From: Nicola Spencer on behalf of Planning
Sent: 29 January 2018 11:36
To: Planning Scanning; Planning.Responses
Subject: FW: WA/84/17/PL

Re: Fairmeads farm - demolition of existing structure & paddock & erection of farm building for the secure storage of farm machinery fertilizer hay & straw (resubmission following WA/63/16/PL).

Title Proposed Agricultural building for secure storage of farm machinery, hay and straw at Fairmead Farm Binsted lane Binsted Arundel BN18 0LQ		Client Deborah Osborne Blackmill Cottage Blackmill Lane Norton Chichester West Sussex PO18 0JU
Scale 1:500	Date 27/11/17	Draw No RA/674/500 .IC Block plan

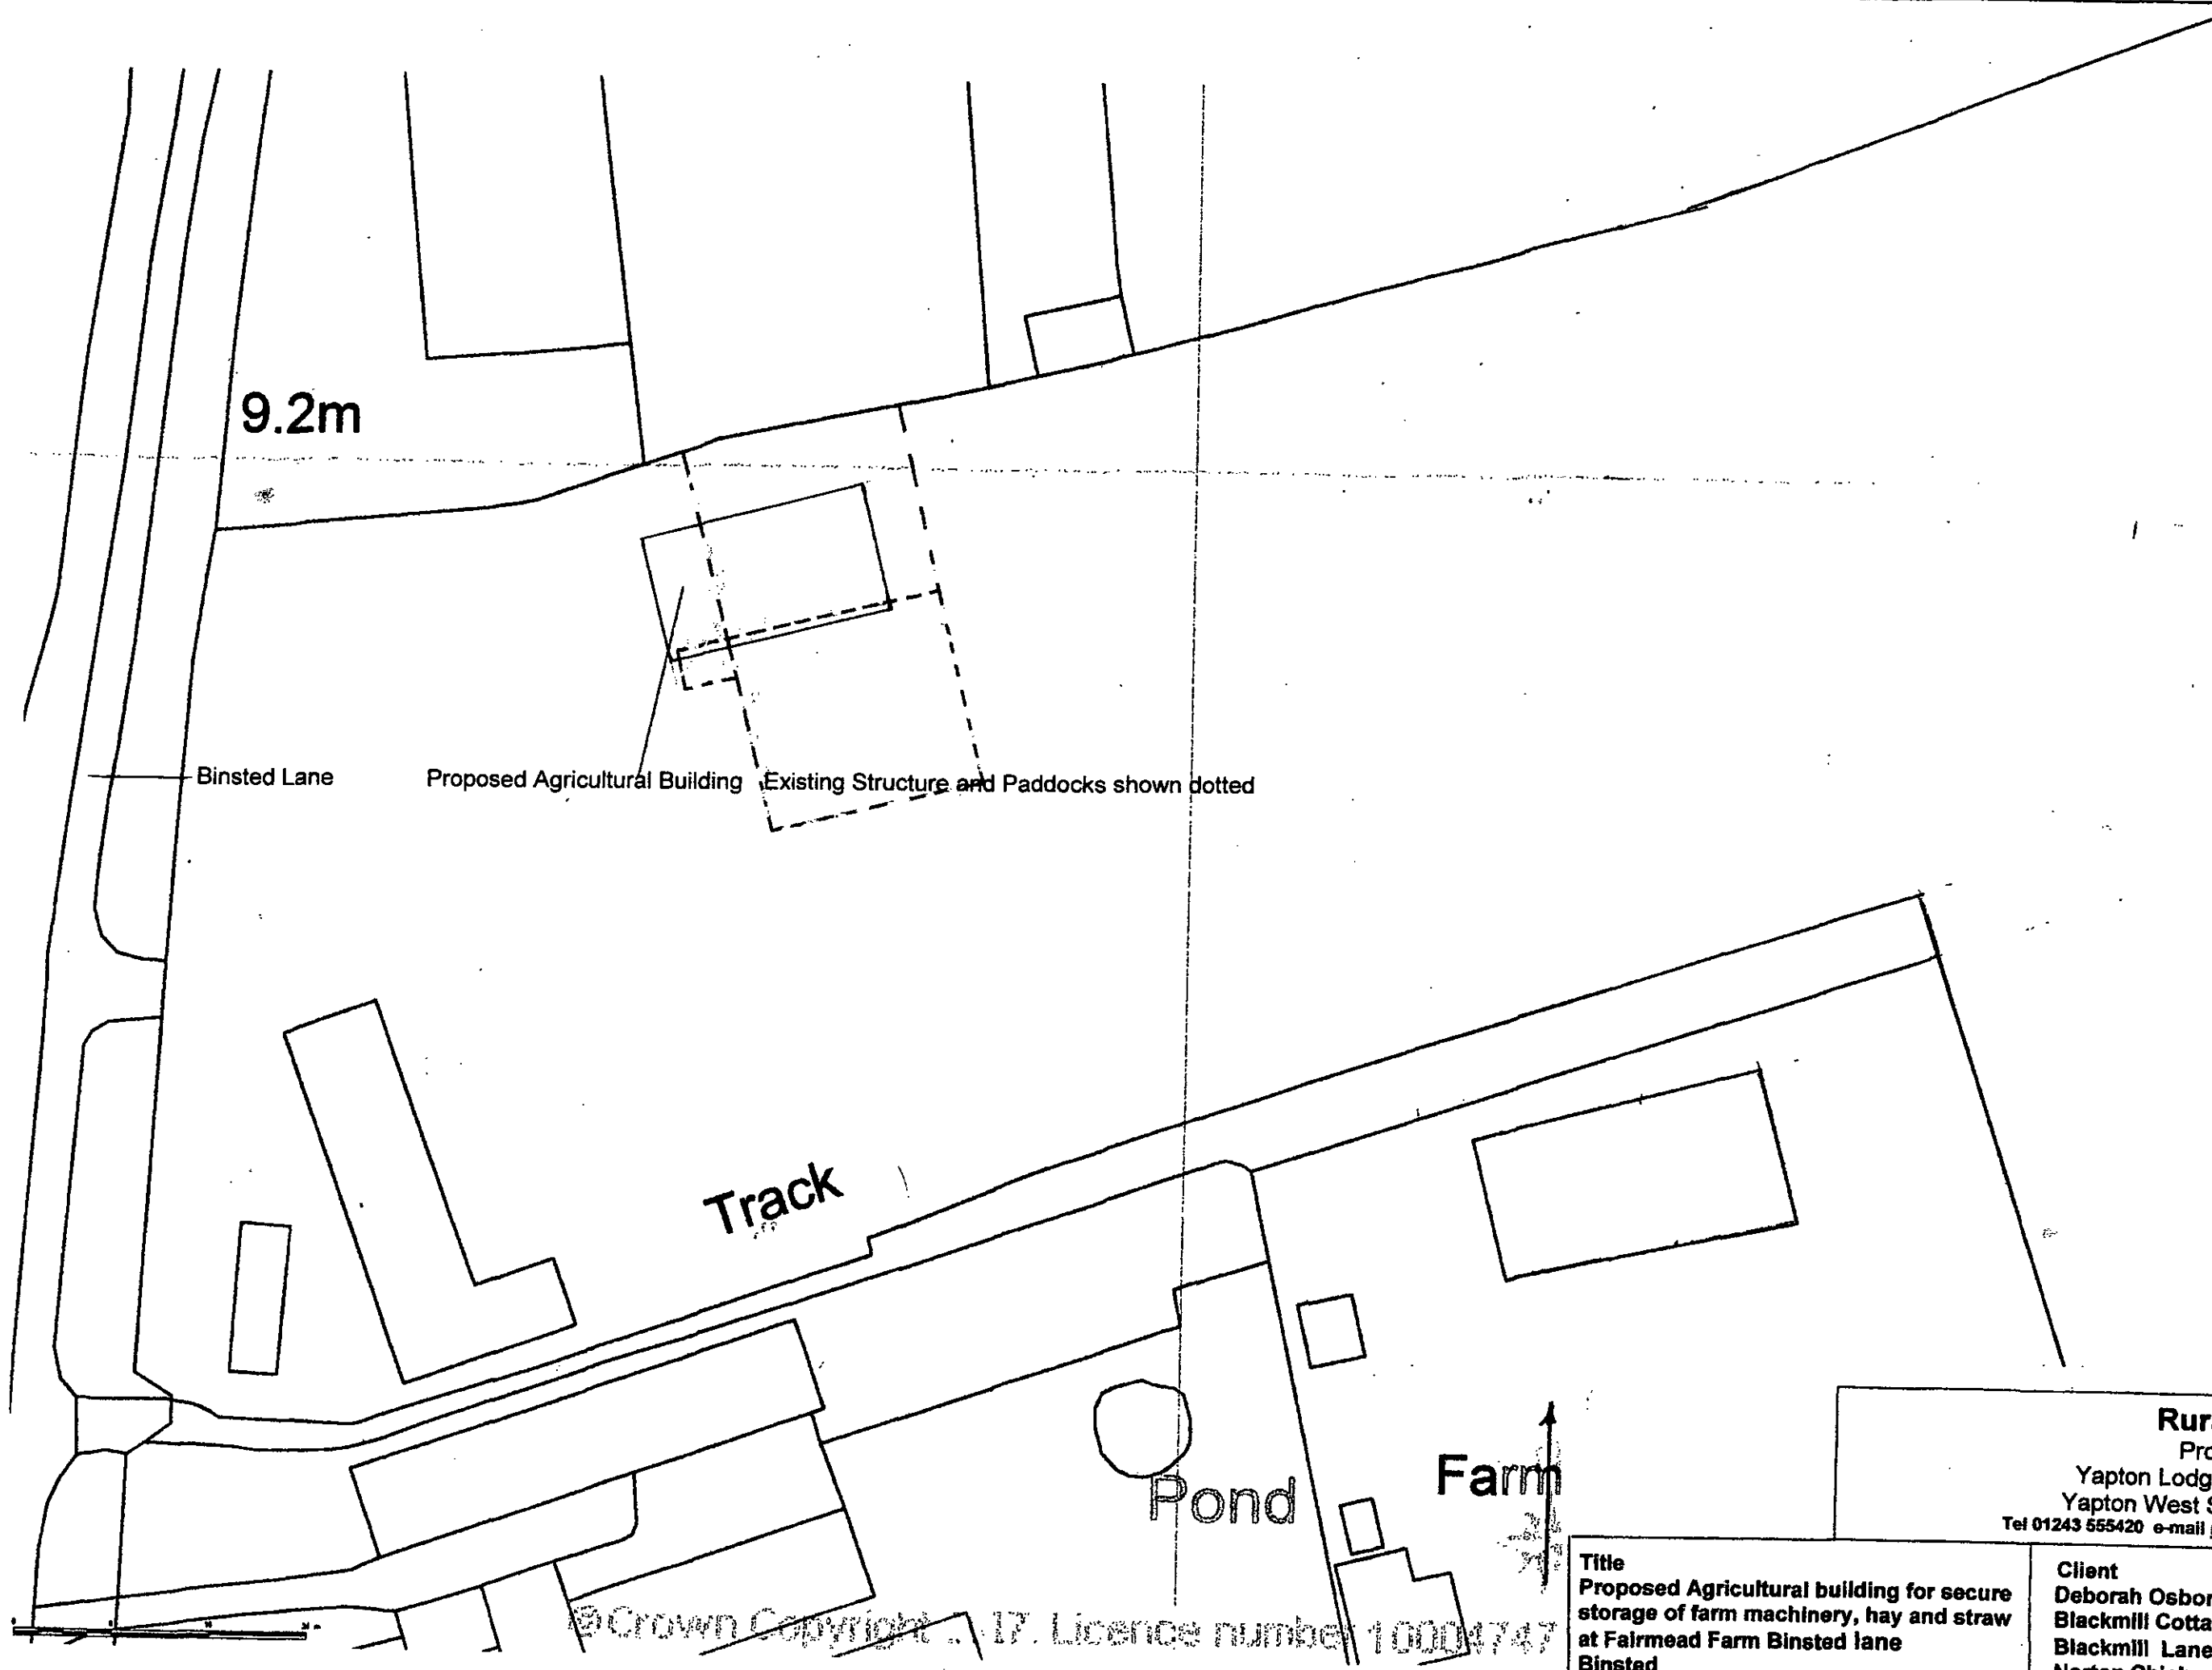
I am particularly concerned about the attempt on Plan RA/671/500 with it's dotted lines to suggest that a structure exists when it doesn't and the "dressing up" of this and the previous application as "agricultural" when they clearly are not.
